Engineers Comments Regarding Surface Water Drainage

Application Reference:	A/20/26/DOC	Reviewer Reference:	ADC/EXT5/AF
Planning Officer:	Jessica Riches	Date of Review:	26/02/2026
Site Name:	Land North of Water Lane Angmering BN16 4EJ		
Application Description:	Approval of details reserved by condition under A/248/21/PL relating to condition 29 -As Built Drainage.		
Assessment Number:	1

Response	Condition 29: Further information required
-----------------	---

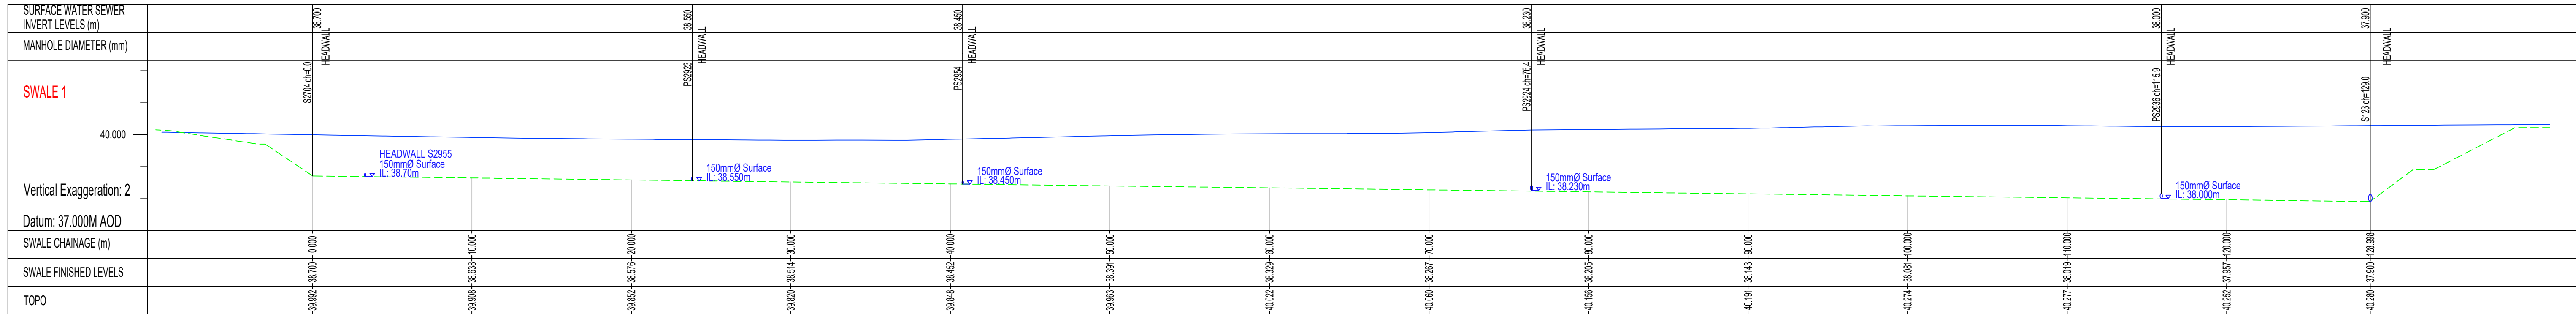
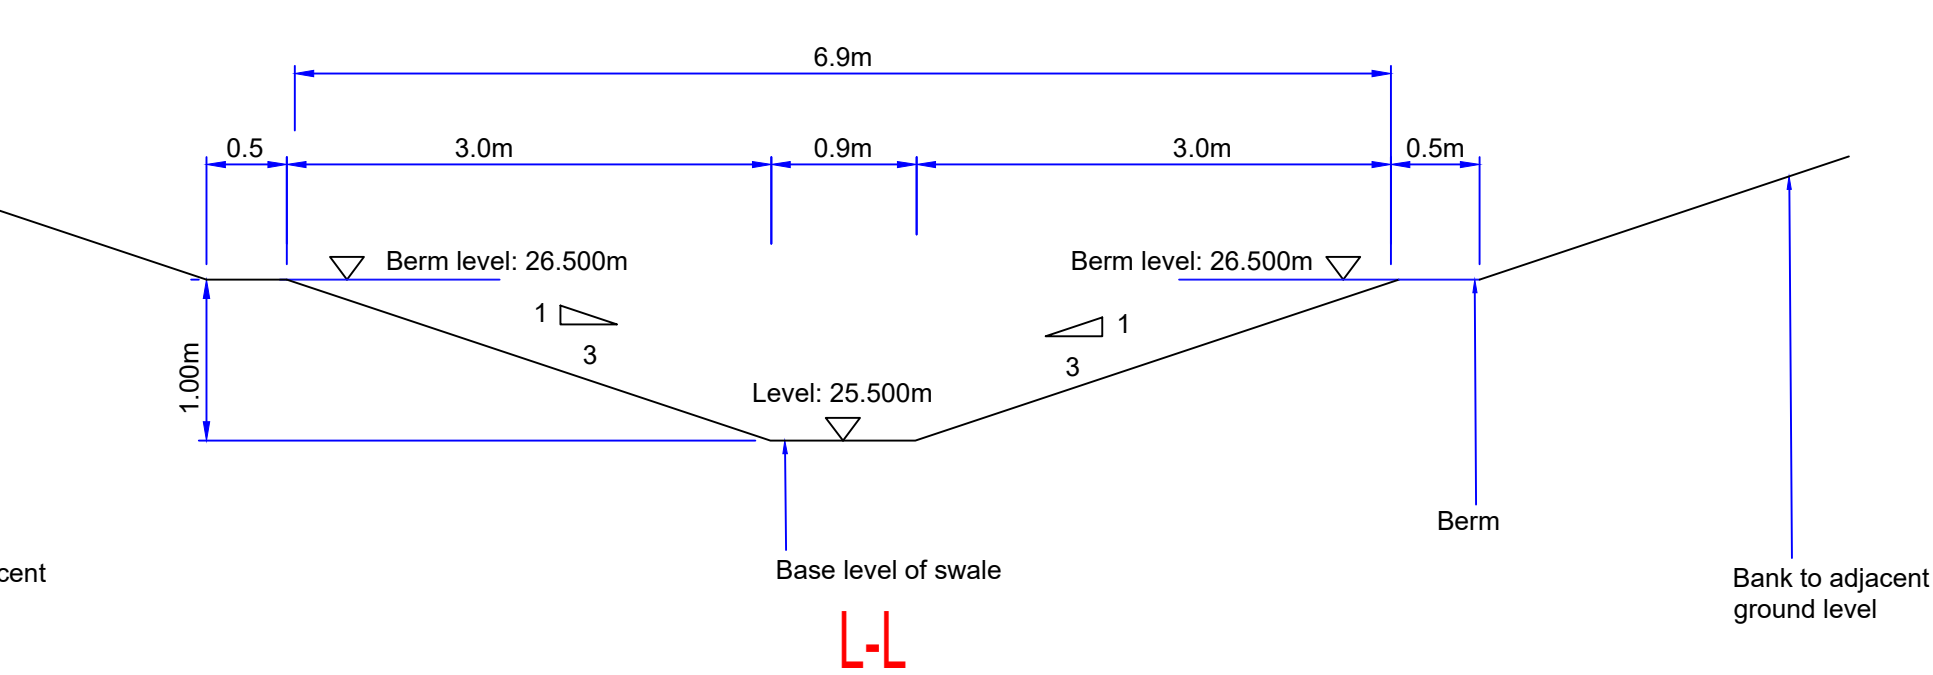
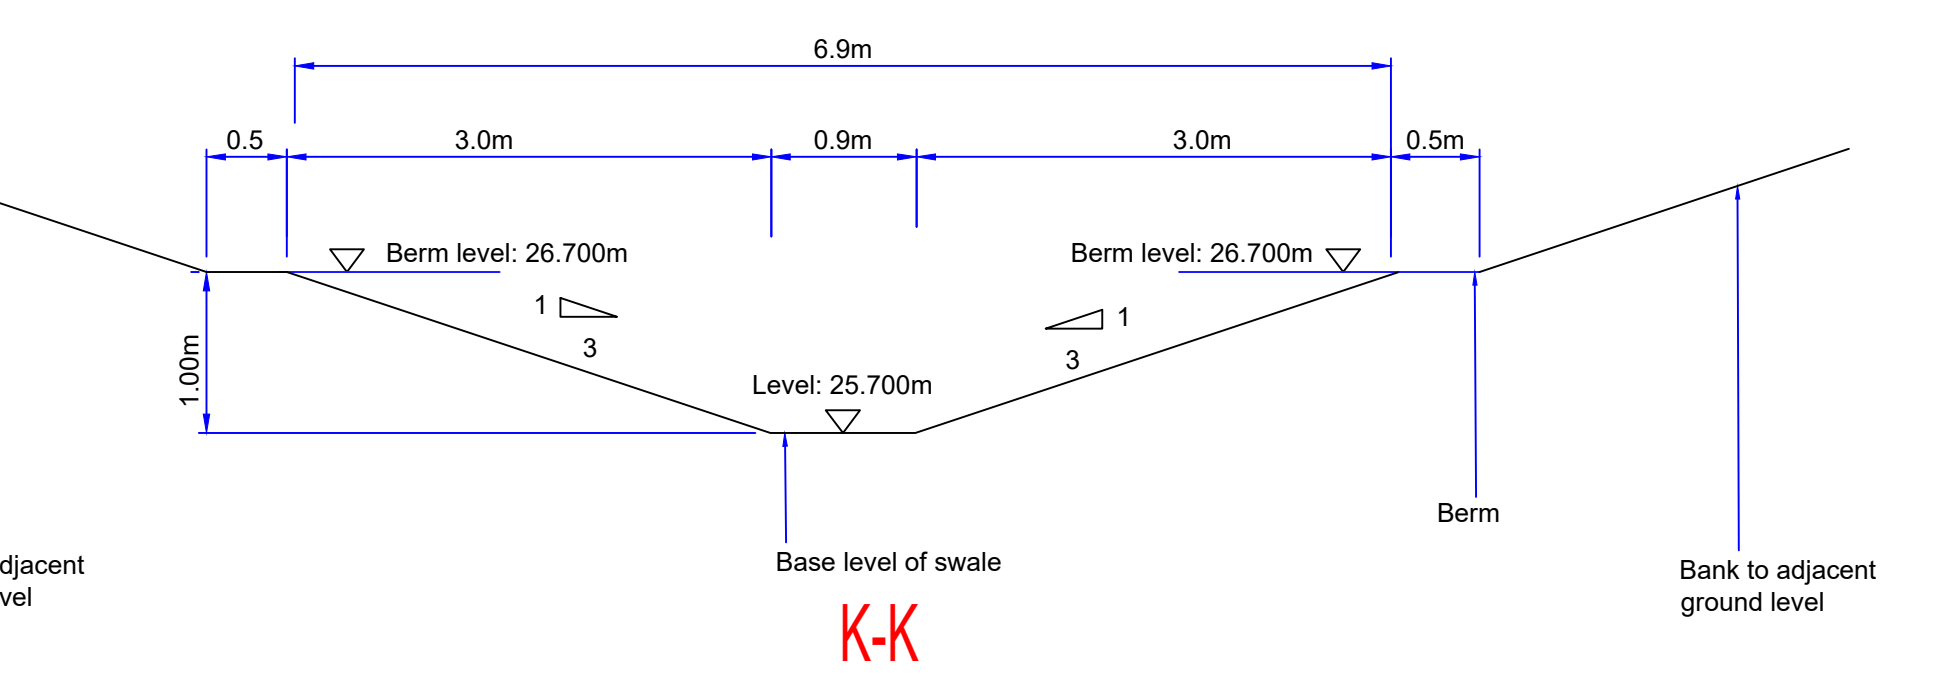
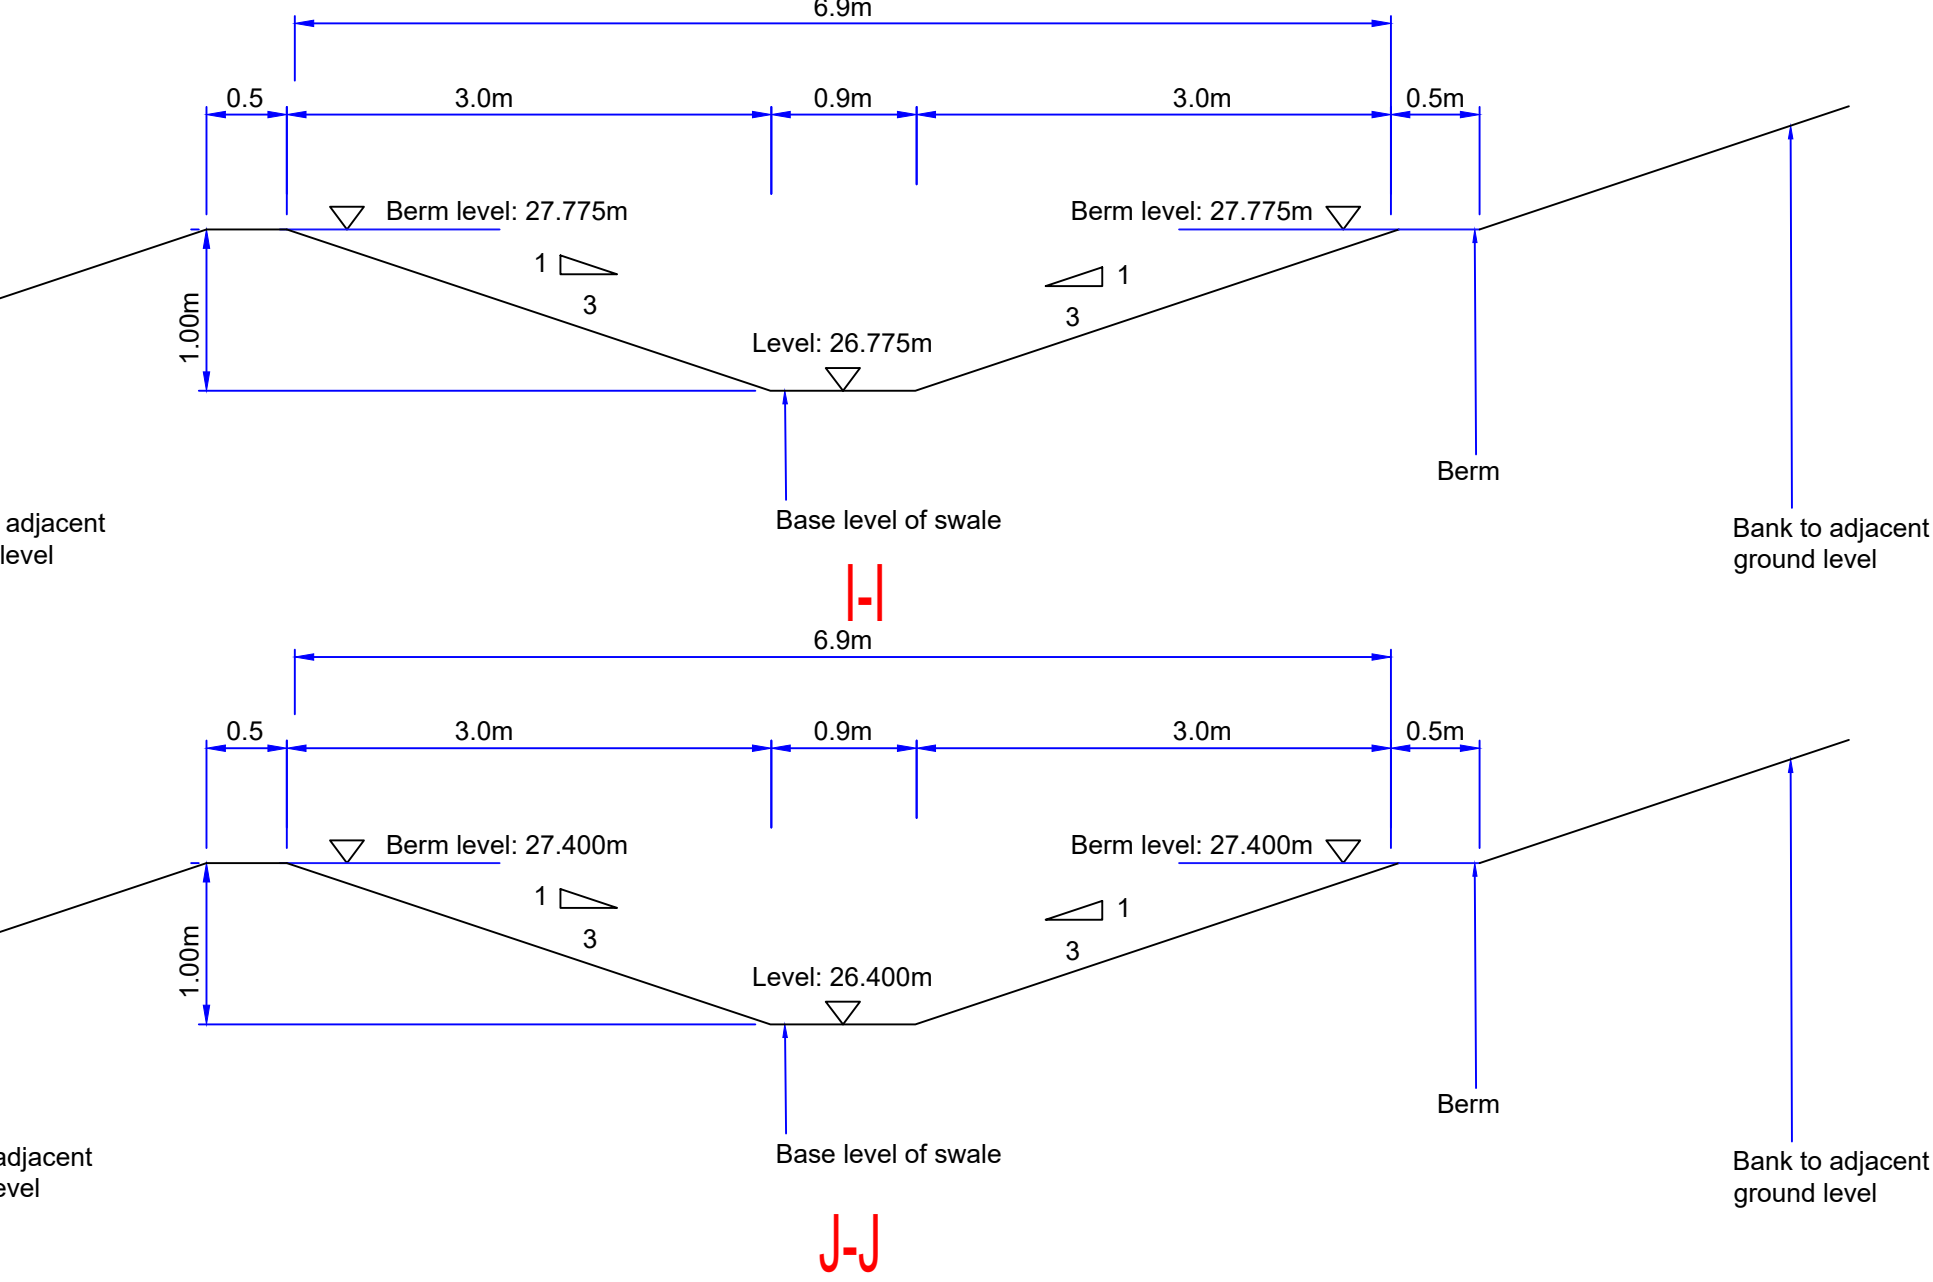
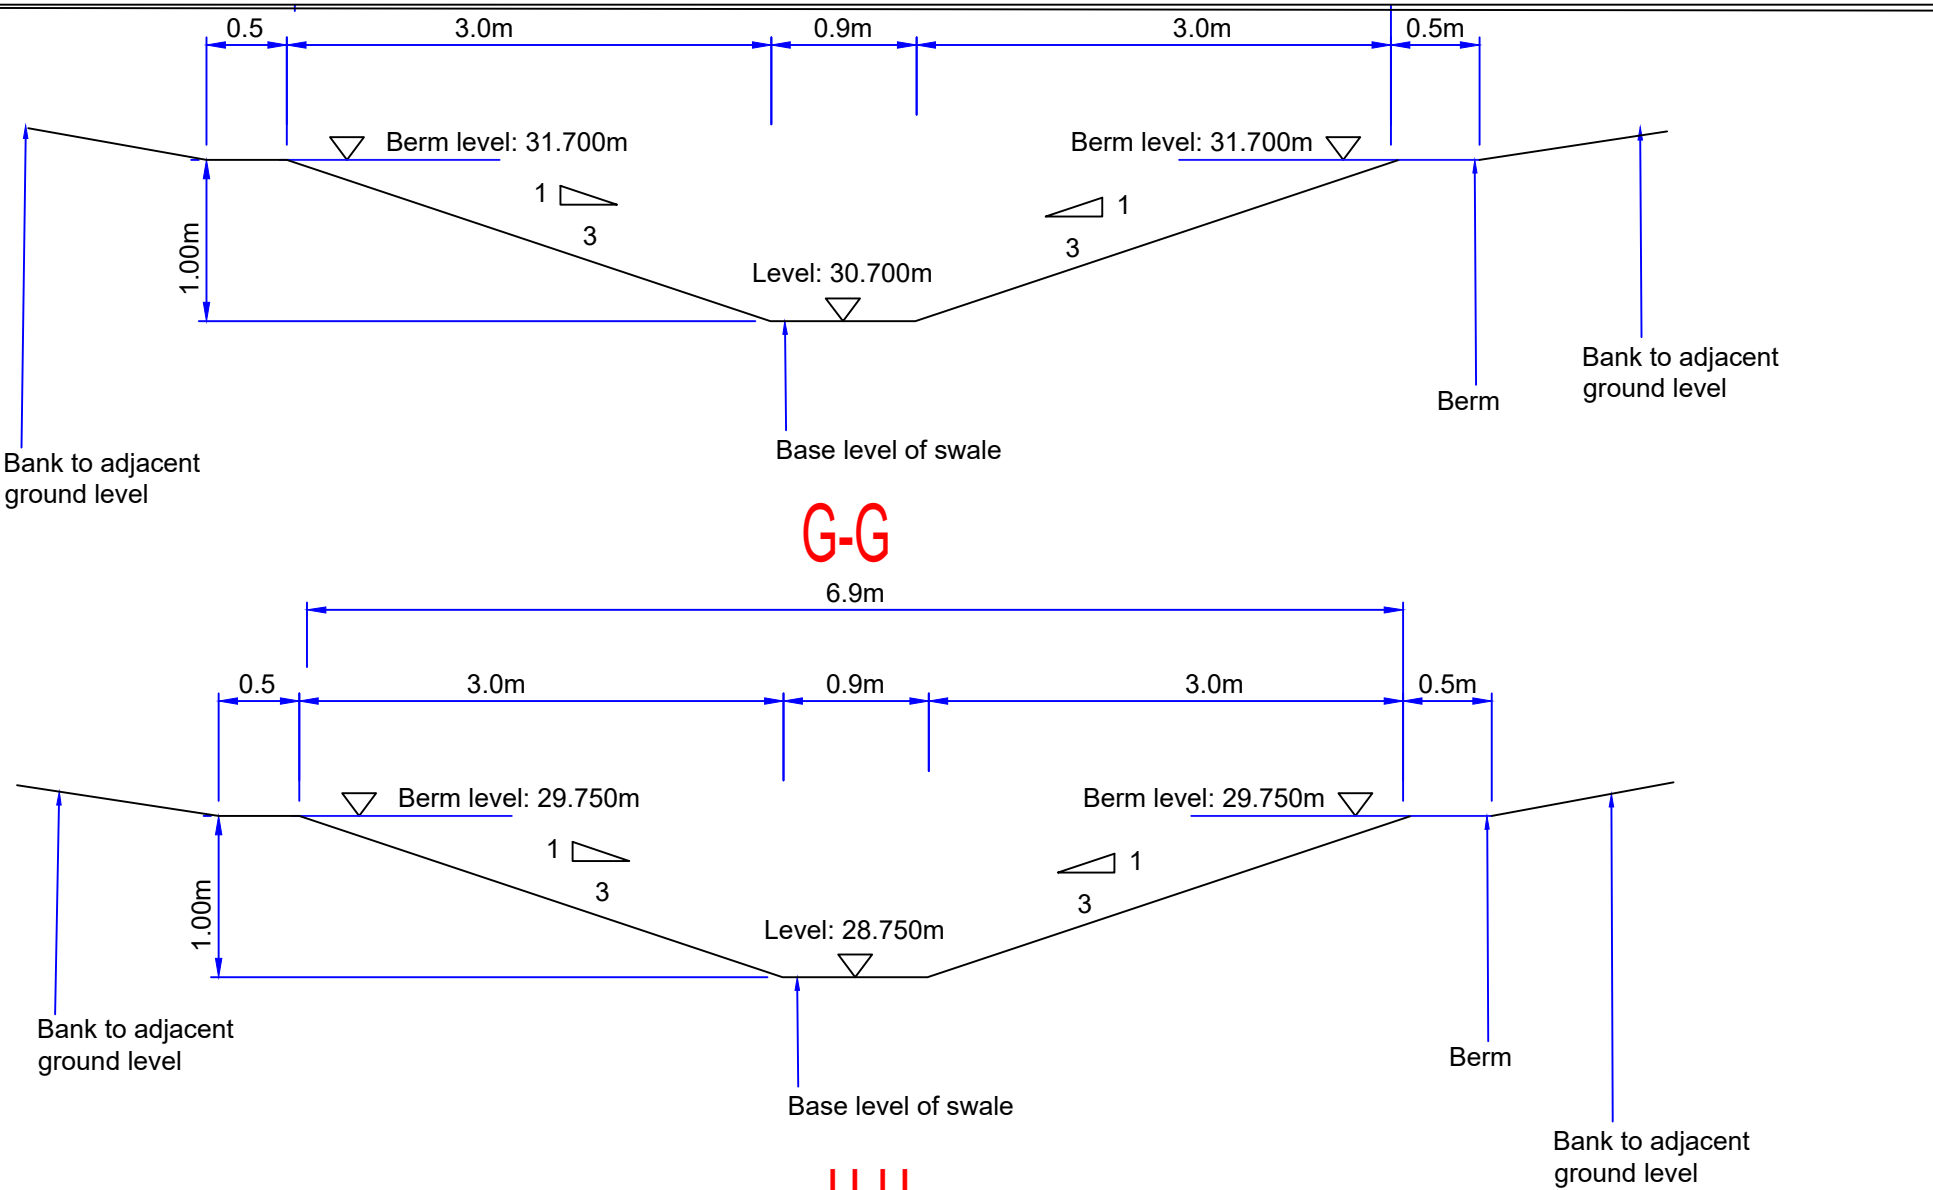
5.	The swales include storage provision and/or design storm flows as part of the sustainable drainage system. An as built measured survey should be provided and confirmation through volumetric comparison with the approved technical design that the as built capacity is fit for purpose.
